Planning and Building Control
South Holland District Council

Our ref: 25_33356_P

Site Location: Land to the west of Langary Gate
Road Fleet Coy Spalding PE12 0RU

Summary of Proposal: Change of use of previously reclaimed land to enable a mixed residential and equine use through the standing of two residential static caravans and two touring caravans and erection of two stables and ancillary works to create a home for a Gypsy / Traveller family

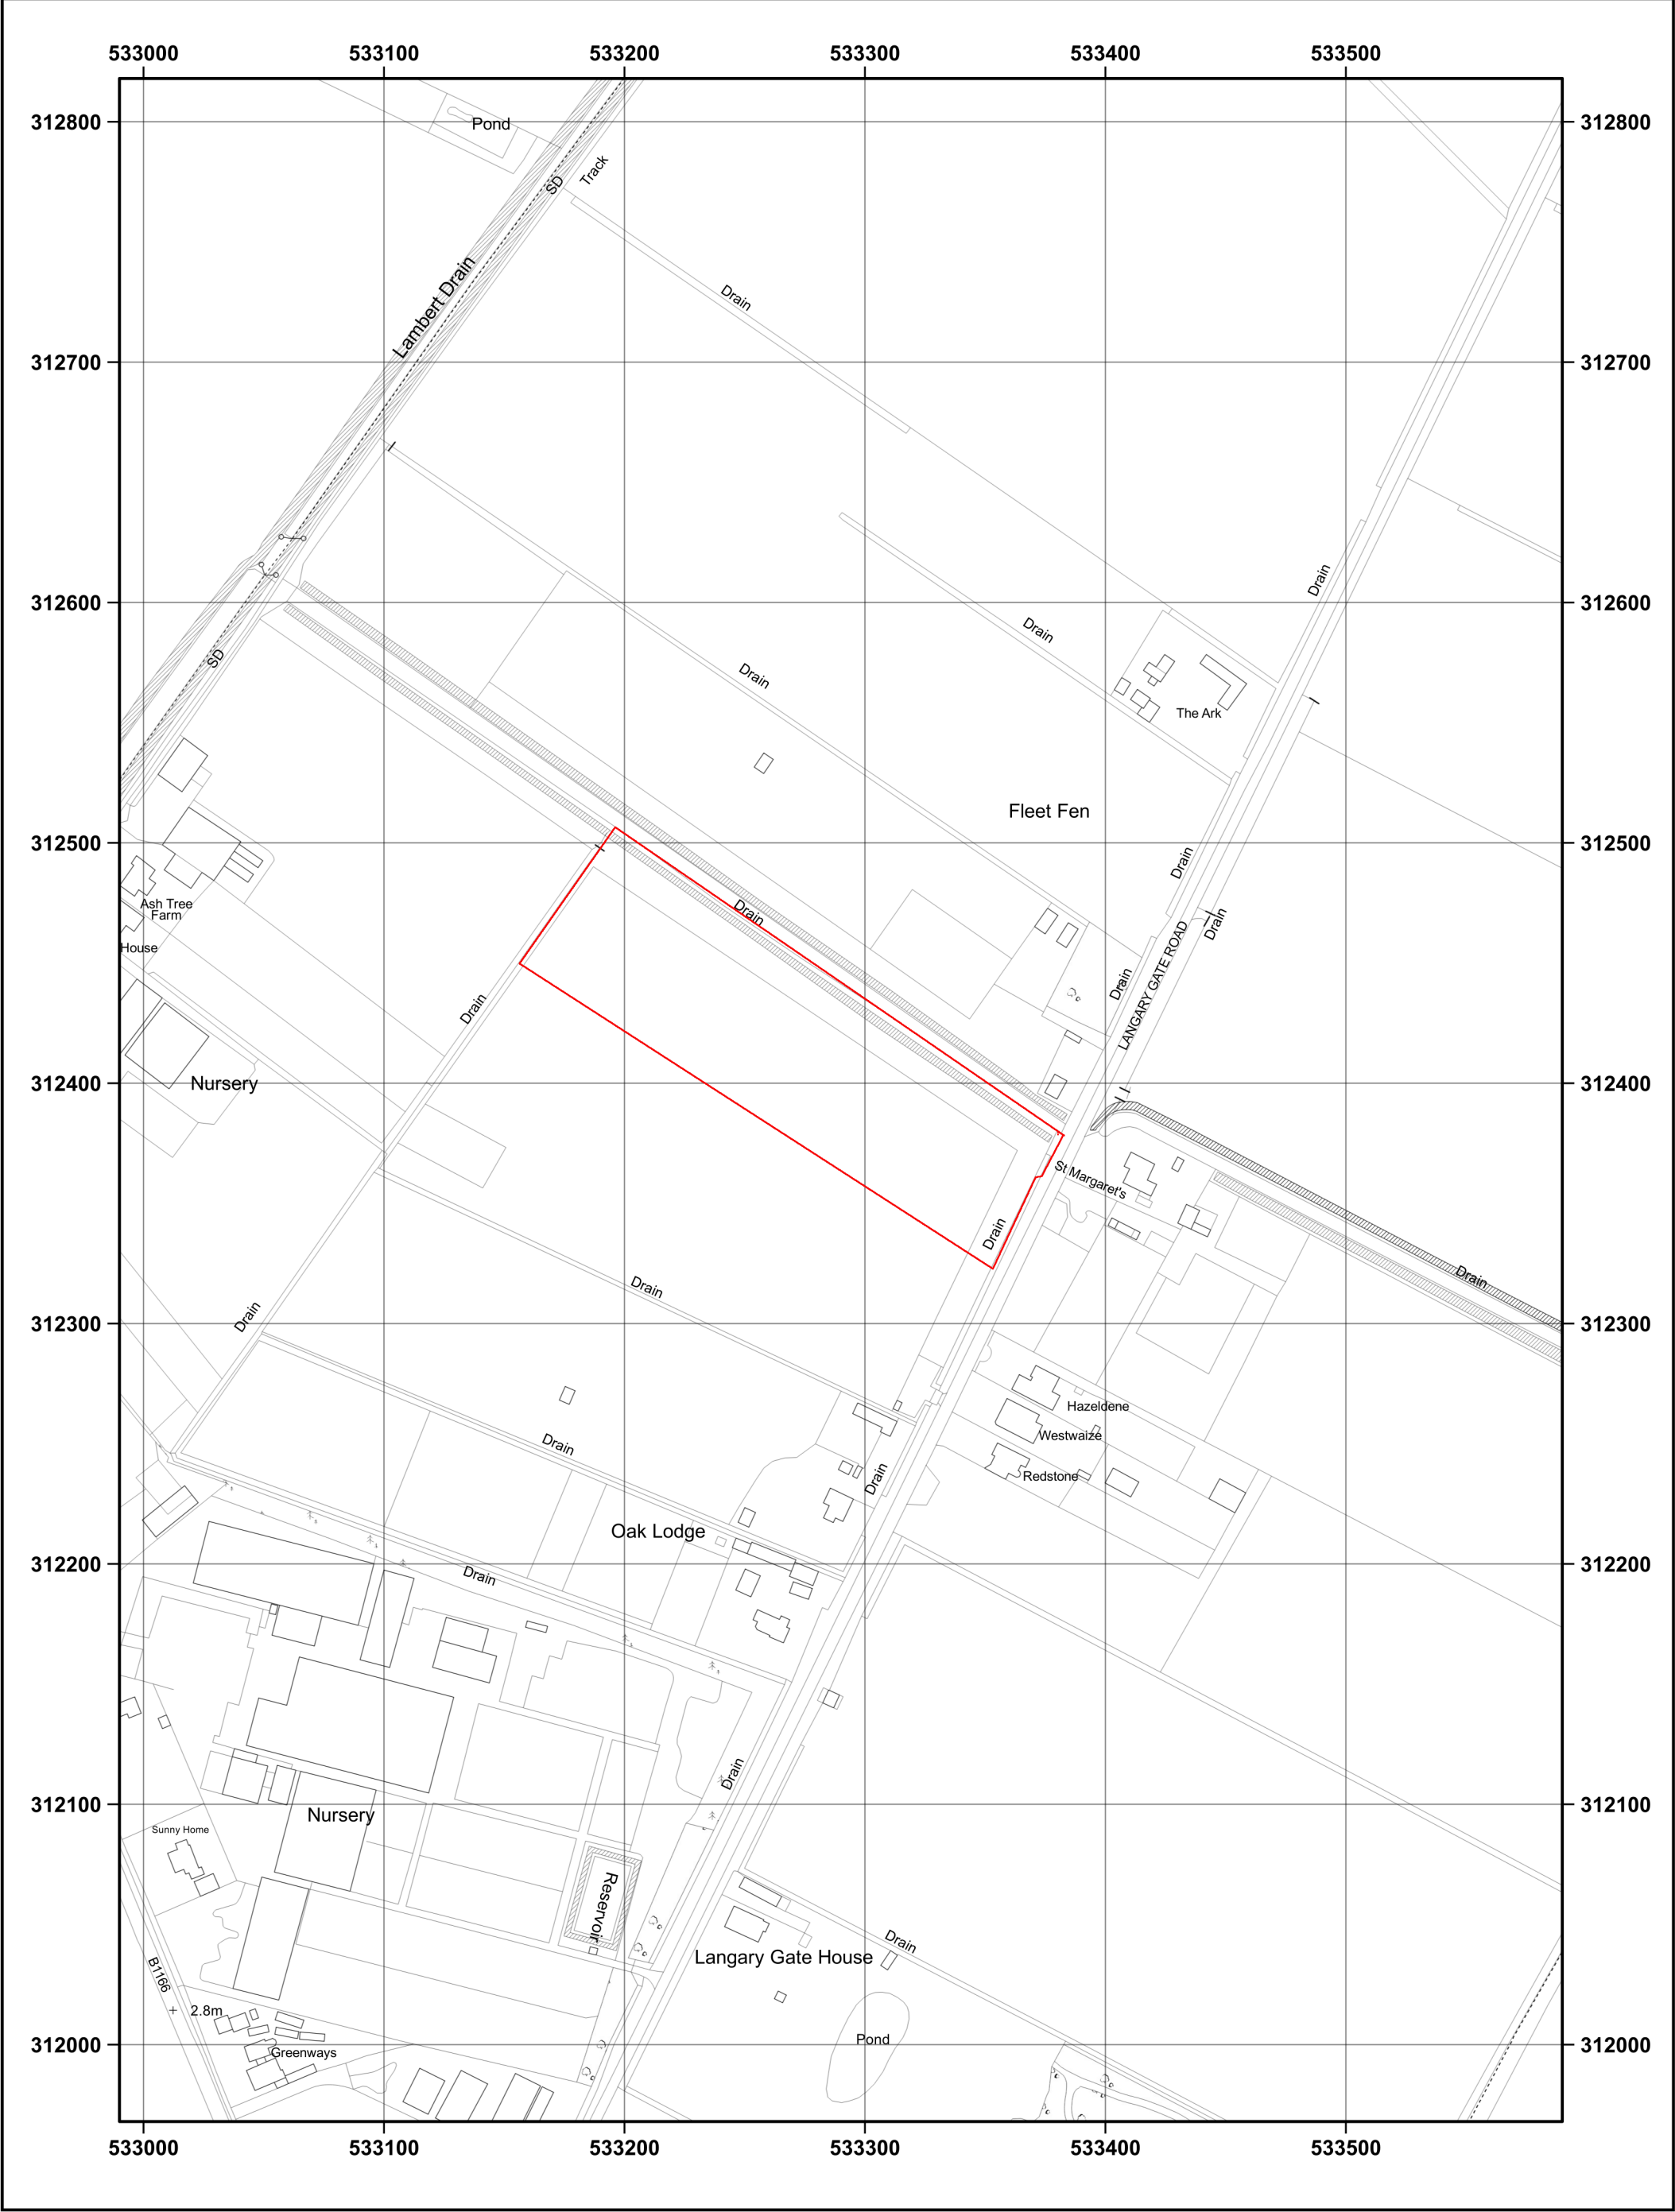
At the northern boundary the Location Plan (submitted 29/07/25) shows the site outlined red extending from the top of bank and down the batter to the landward toe of the 'Drain'. This land belongs to the Board (Part of Lambert Drain and Fleet Drain and Main Road Drain, Holbeach Spalding, known operationally as E31 Lambert Drain Connection). The Board raised this issue about the extent of land ownership under a previous planning application at this site (reference H05-0985-24). The applicant has provided the same Location Plan (production date 29/07/2024) and has failed to take account of the Board's land ownership on the application form.

The Board objects on the strongest terms to any encroachment upon its landholding. The applicant needs to make the correct declaration on their application, adjust the site boundary line landwards as per Land Registry maps, amend the site area to which the application relates and submit a revised Location Plan with the correct red line boundary marked.
